CITY OF ALBUQUERQUE

**Re: SAD 228 Lot 7 Block 10
6509 Petirrojo NW
Request for Permanent C.O. - Accepted
Engineer's Stamp dated: 12-14-18 (D10D003P7)
Certification dated: 8-23-19**

**RE: 6509 Petirrojo Rd. NW
Grading and Drainage Plan
Engineers Stamp Date 11/29/14 (D10-D003P7)**

Based upon the information provided in your submittal received 12/1/2014, the above referenced Grading and Drainage Plan cannot be approved for Grading Permit or Building Permit until the following comments are addressed.

Development, Inc. 8860 Desert Finch Ln NE Albuquerque, NM 87122 (505) 280-4553 GRADING AND DRAINAGE PLAN

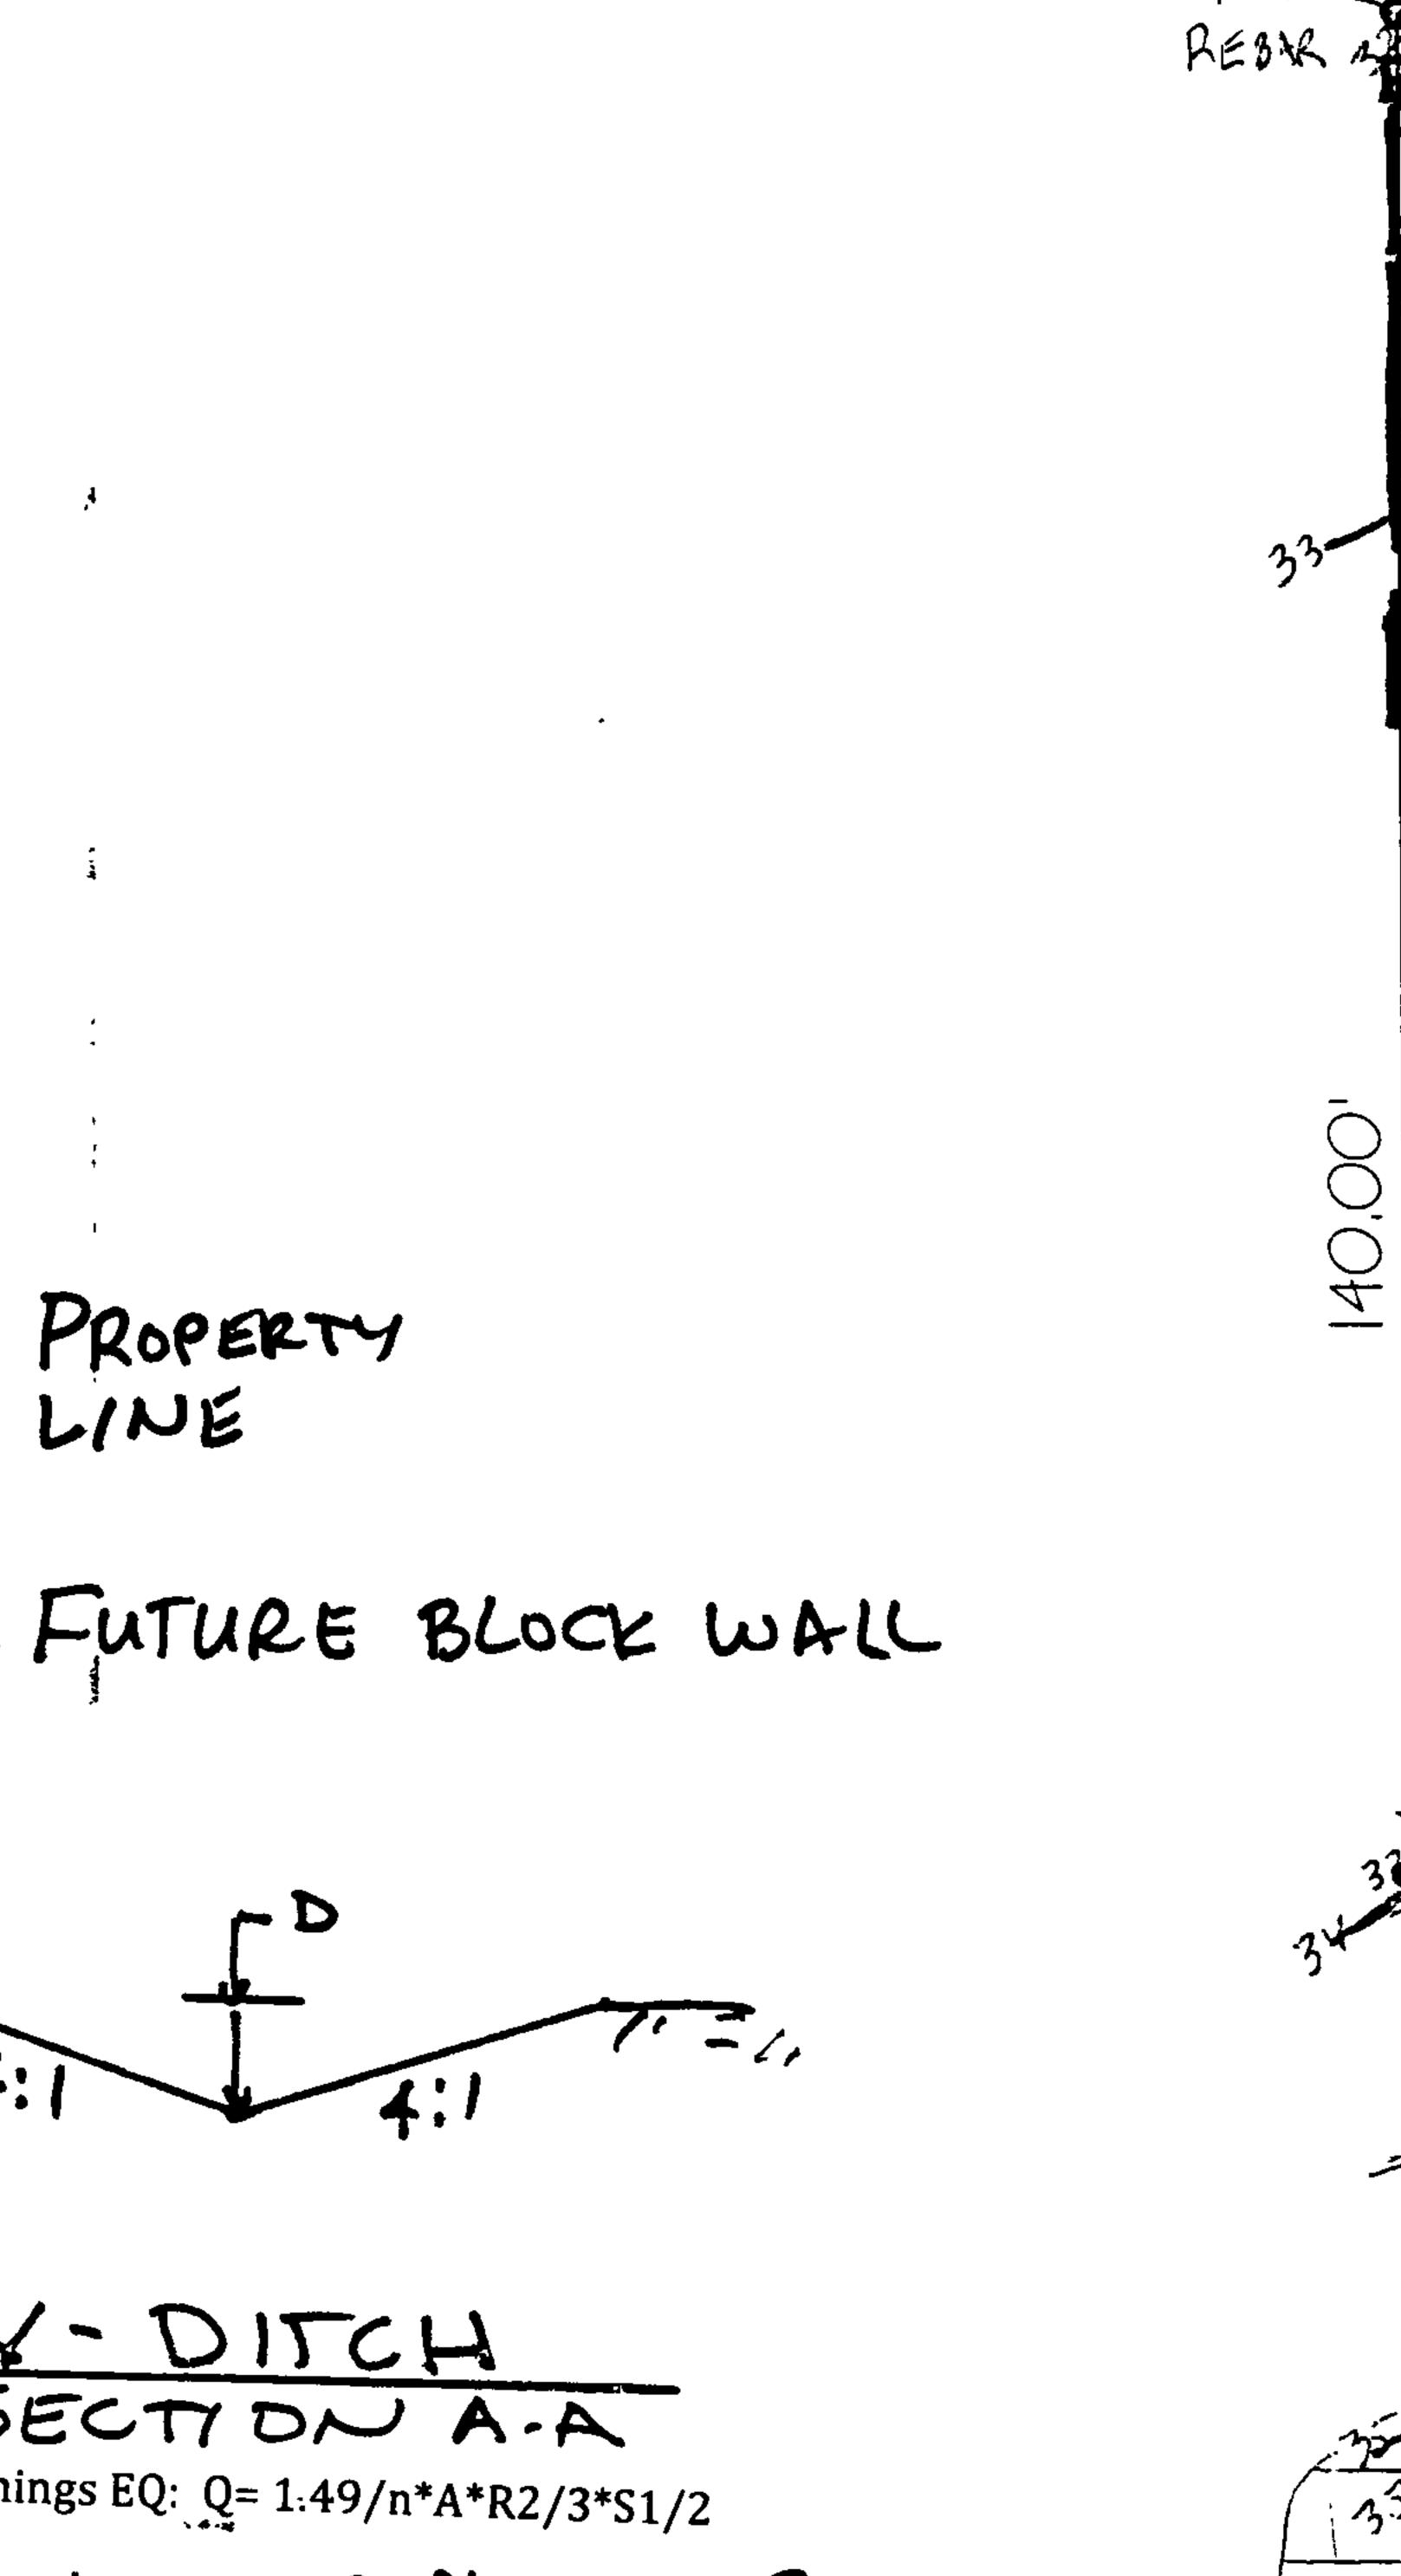
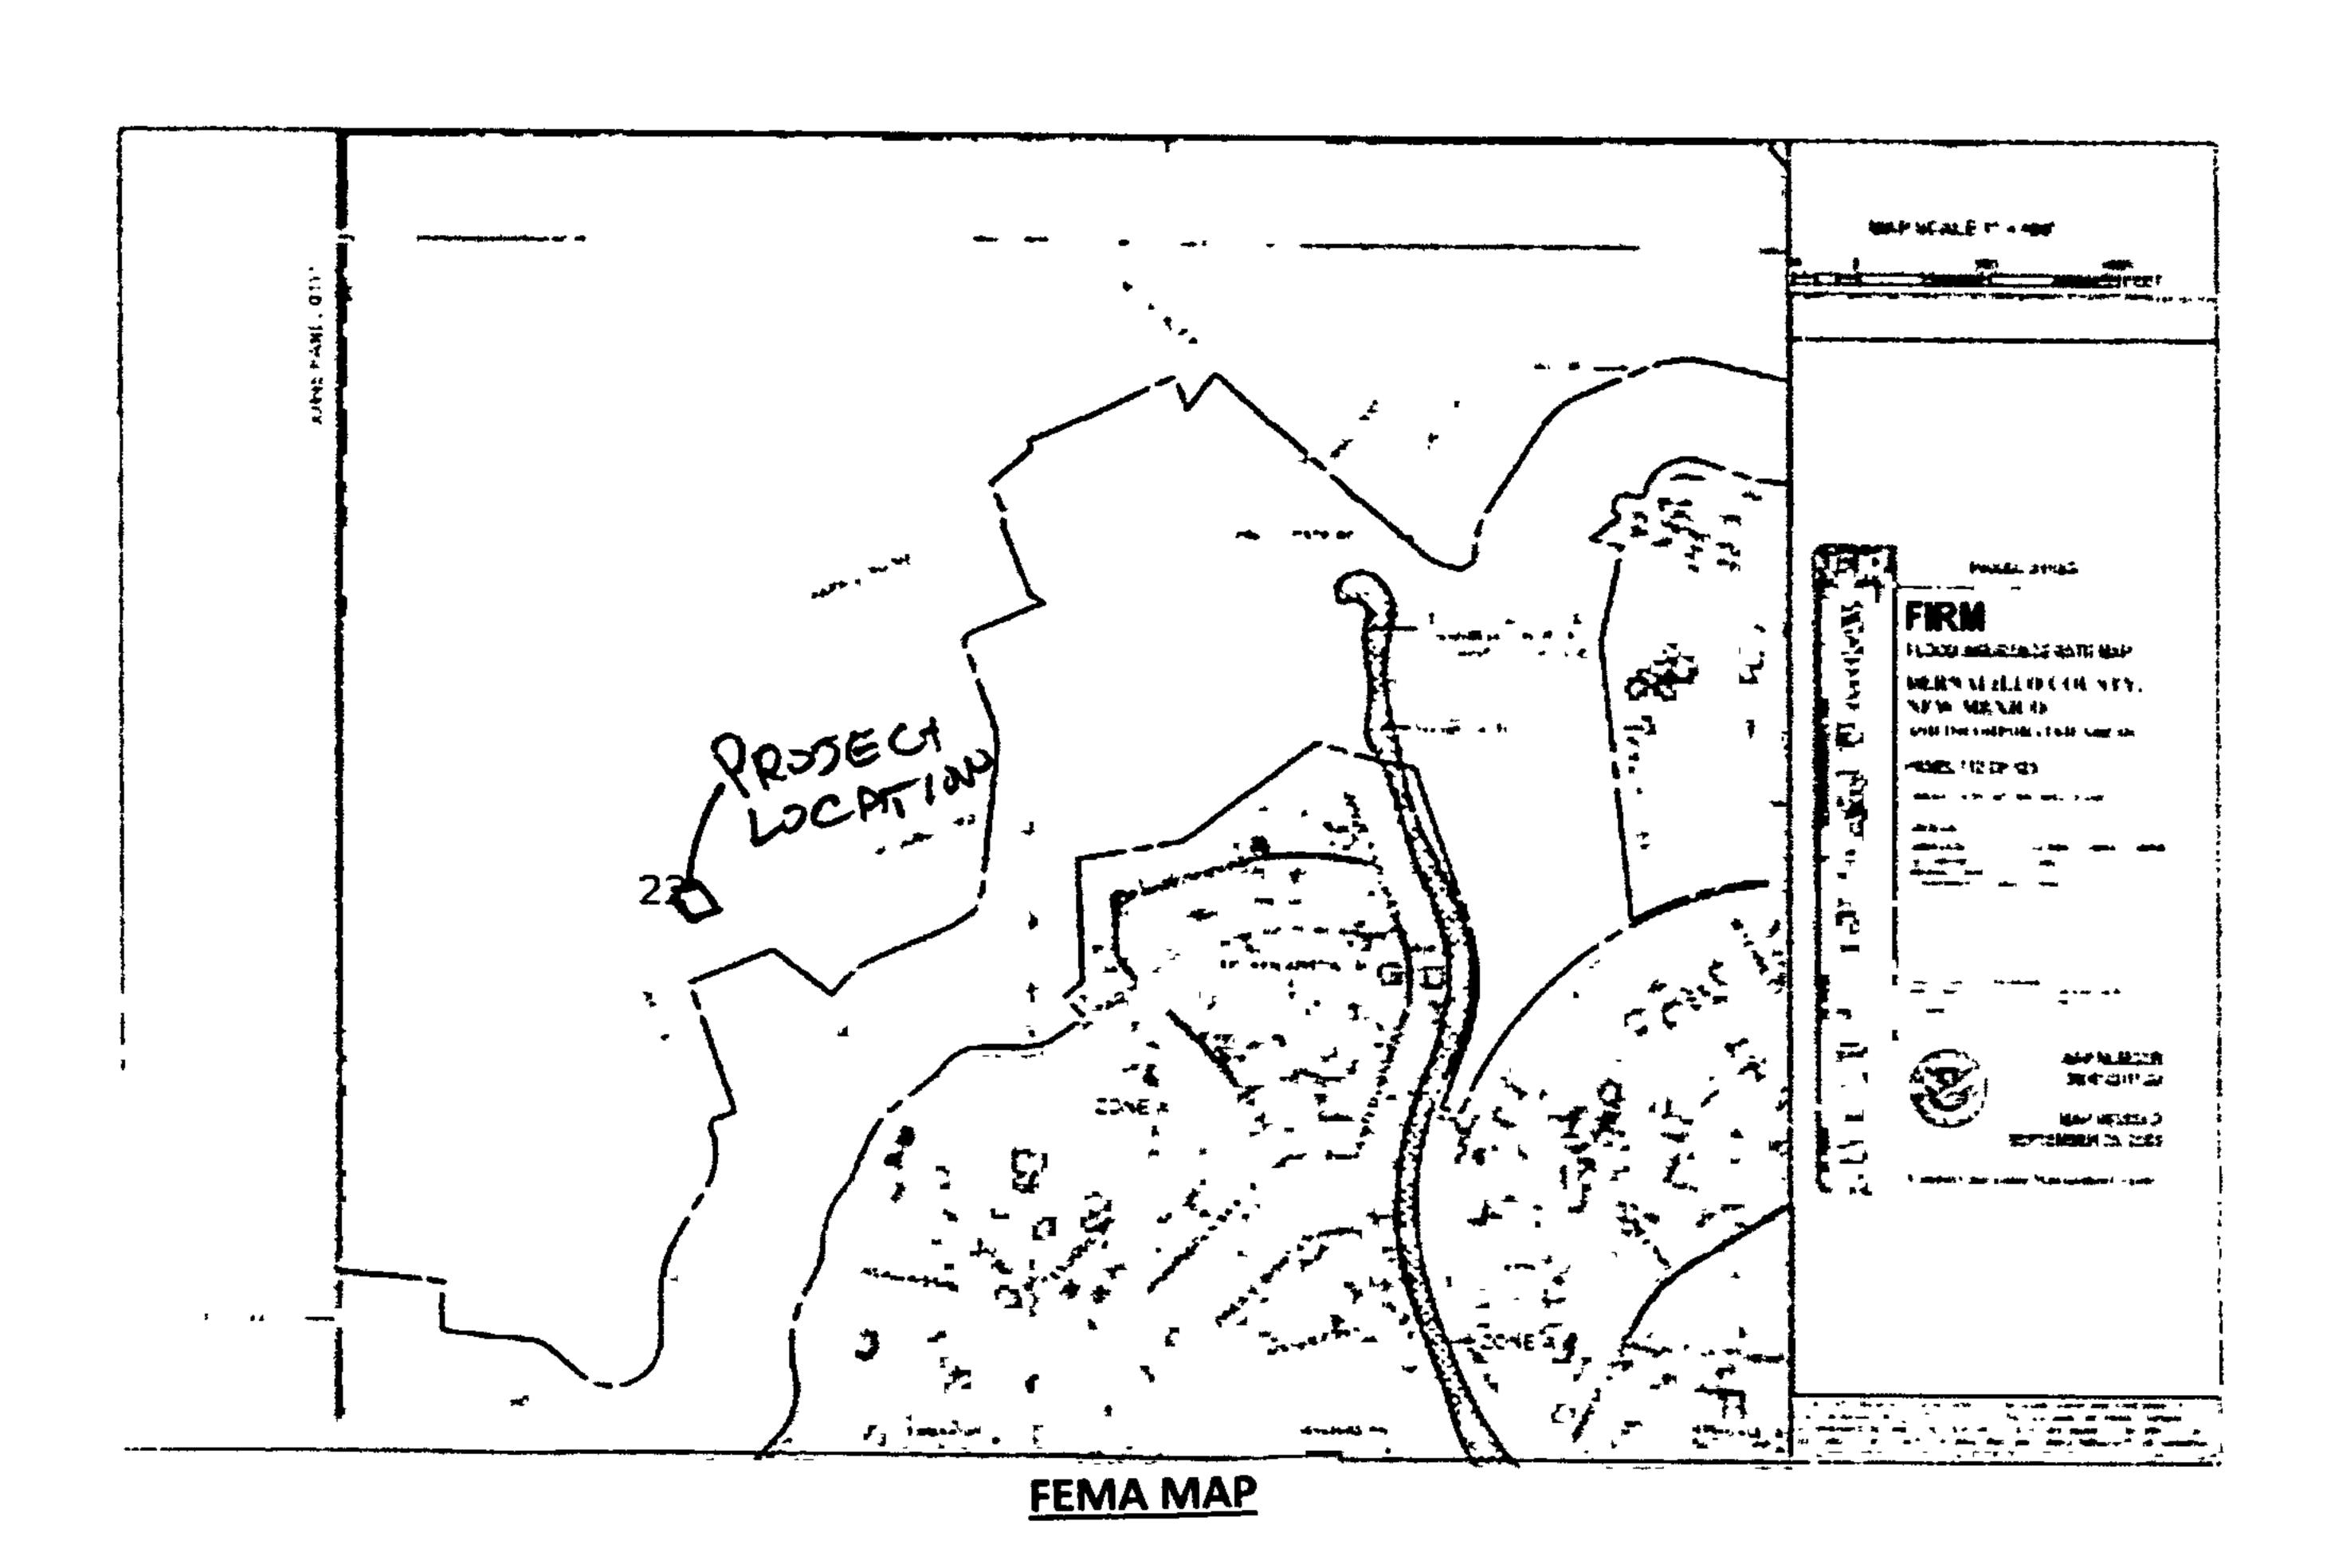
- Provide a Vicinity map, a FEMA map or designation, a narrative.
- Mention of the first flush per EPA standards is required. The amount required is .34" times the impervious area.
- Provide a section of the V Ditch and calculations for the ditch. 13.0cfs seems a bit too much. Is the ditch a shared ditch, if so where will the block fence be placed?
- What are the inverts of the openings? Is this a block fence?
- What is the flow line in the street?
